From: michael collins <mickael.collins@hotmail.com>
Sent: Tuesday, 7 July 2015 4:42 PM
To: Robert A Byrne
Subject: FW: Comment on SSD 5248 Gazcorp Response to Submissions

I am unsure if we are only objecting to stage one at this point or if we are objecting to subsequent stages as well. It appears the RtS by Gazcorp is focused on Bldng 10 but we are even more concerned about bldngs 8, 9, and 10 which will impact our rear boundary views and noise from the bldngs.

**DRAWING TITLE**  
**MASTER PLAN**

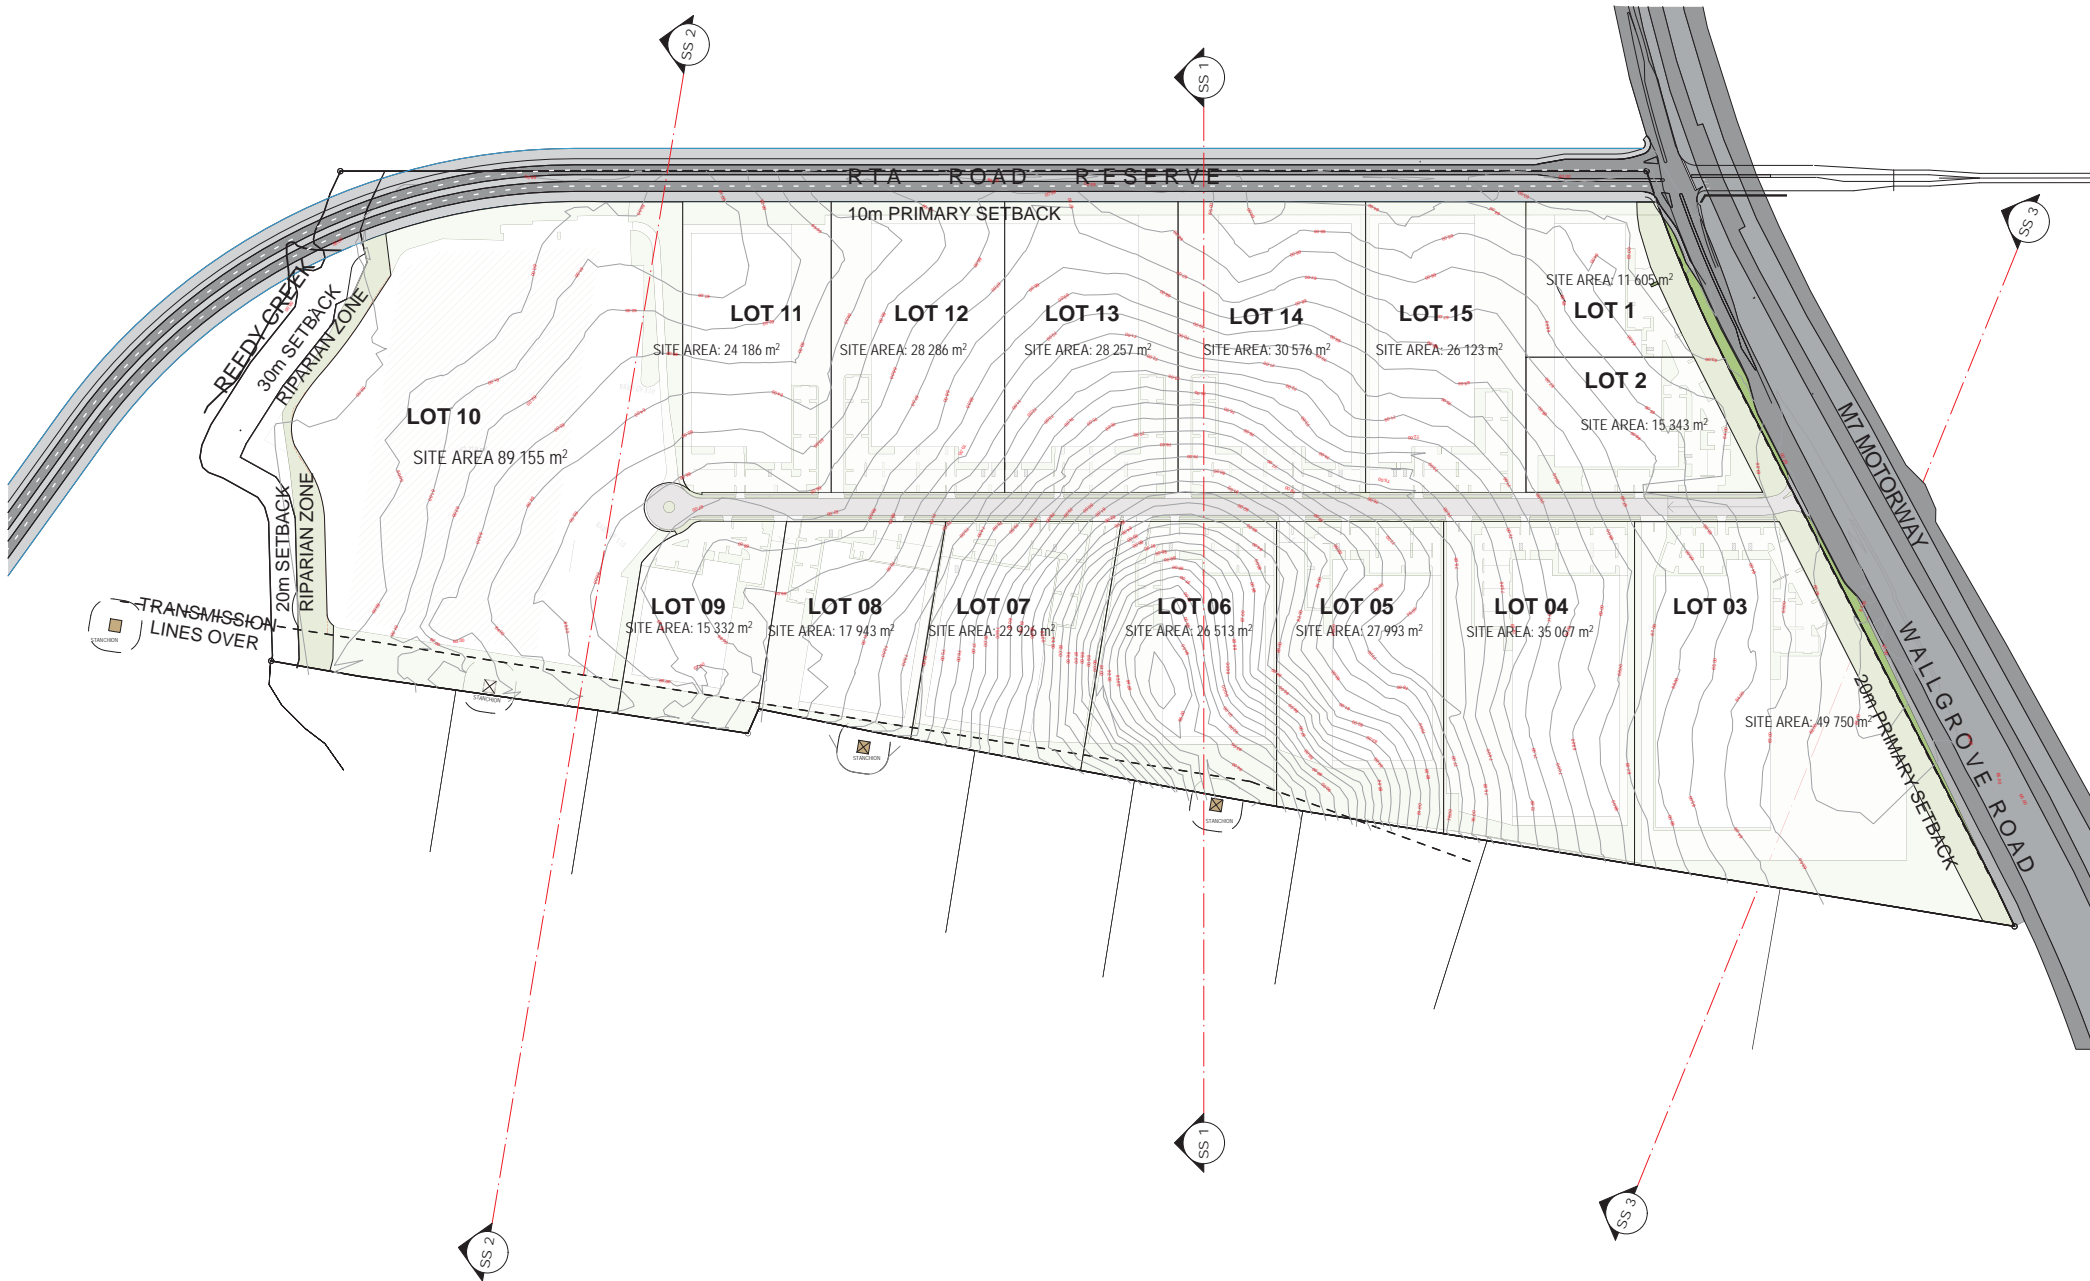
It is apparent from the amended Masterplan that bldngs 7, 8, 9, and 10 will be built so that the rear walls of those bldngs will go right back to the "new widened transmission line easement" line on the site. Any visual or noise abatement will therefore be placed UNDER the transmission lines themselves. Gazcorp claim that bldng 10 will be 40 meters from the side boundary resulting from "the irregular shape of the Southern boundary in some sections". If this is correct then bldngs 7 and 8 are only the width of the transmission line easement off the boundary of our property - DP 1021715. This is TOTALLY unacceptable as no blockage to our line of sight can be built and maintained under the easement.

I submit that an earth mound **must** be constructed between the end of the easement and the walls of these three Bldngs 7, 8, & 9 so that the bldngs are then located a similar distance from the side boundary as is bldng 10. To justify this recommendation I point out that in Gazcorp's response to my original submission No 32 that :

The advantages thus granted to property's whose rear boundary to Bldngs 5-7 (pt of seven only) are not available to my property on DP 1021715. If Gazcorp is prepared to lower these other bldngs to appease the affect of both visual impact and noise on those specific properties then it **MUST** provide our property (and for those homes fronting Flavex lane) a similar concession. This should easily be done by the construction of a dirt mound before those bldngs walls.
